From: Fiona Fitzgerald <Fiona.Fitzgerald@arun.gov.uk>
Sent: 04 February 2021 09:50
To: Planning.Responses <Planning.Responses@arun.gov.uk>
Cc: Raymond Cole <Raymond.Cole@arun.gov.uk>
Subject: WA/7/21/DOC

With reference to discharging condition 2 of WA/48/19/RES:

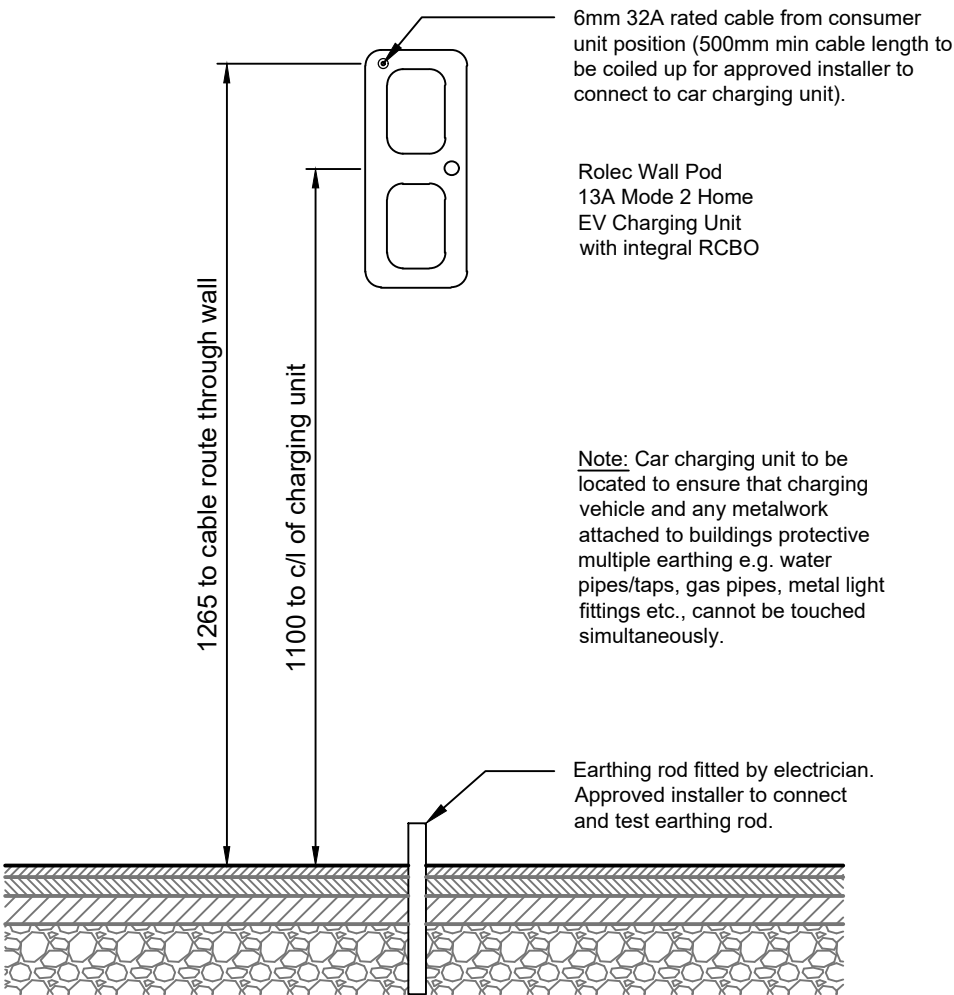
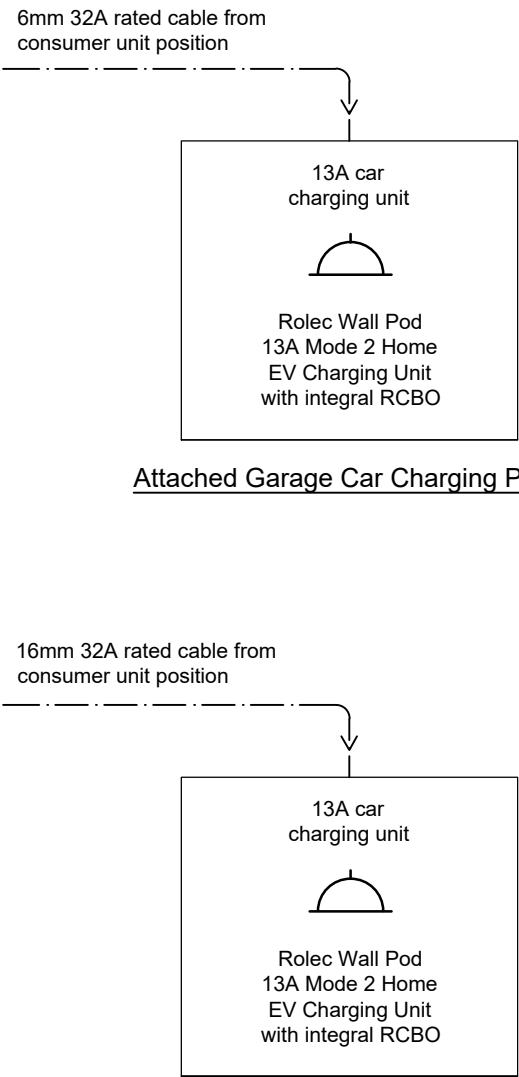
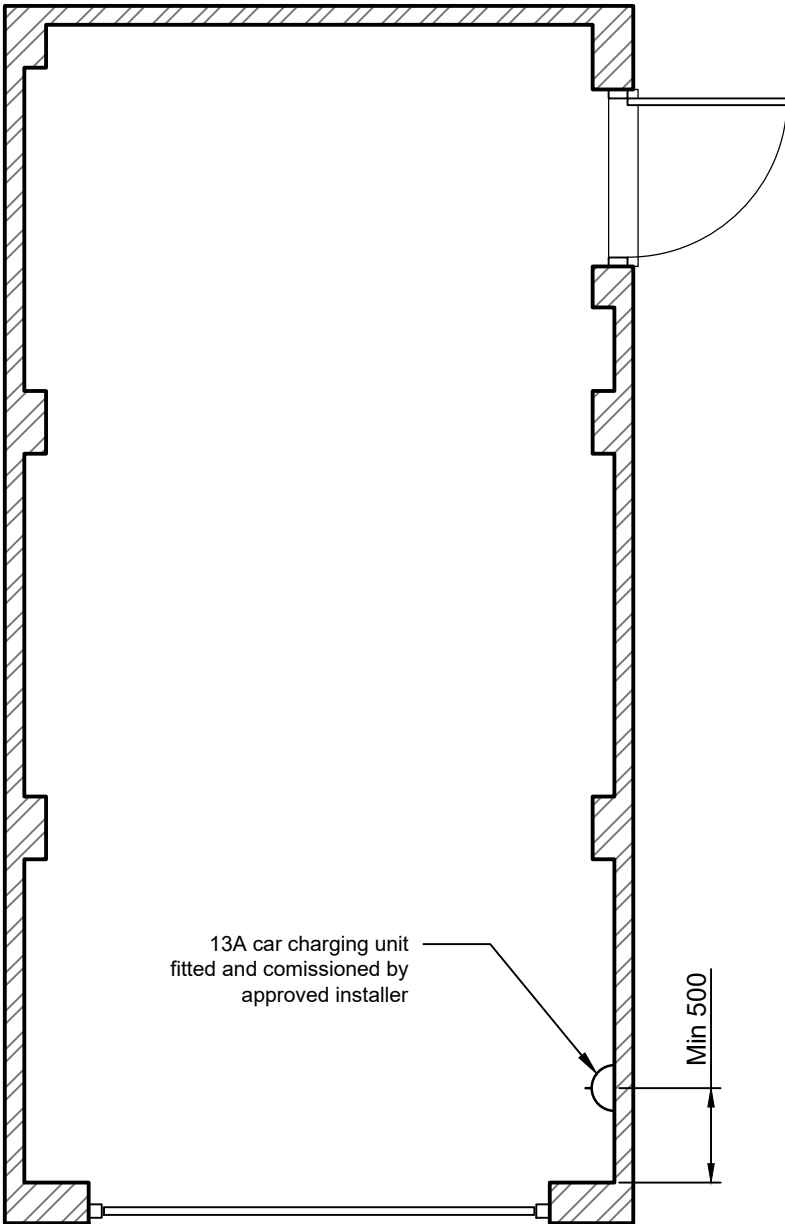
Please could the applicant confirm whether the 293 wall mounted car charging EV points comprises 100% of the houses with a driveway or a garage?
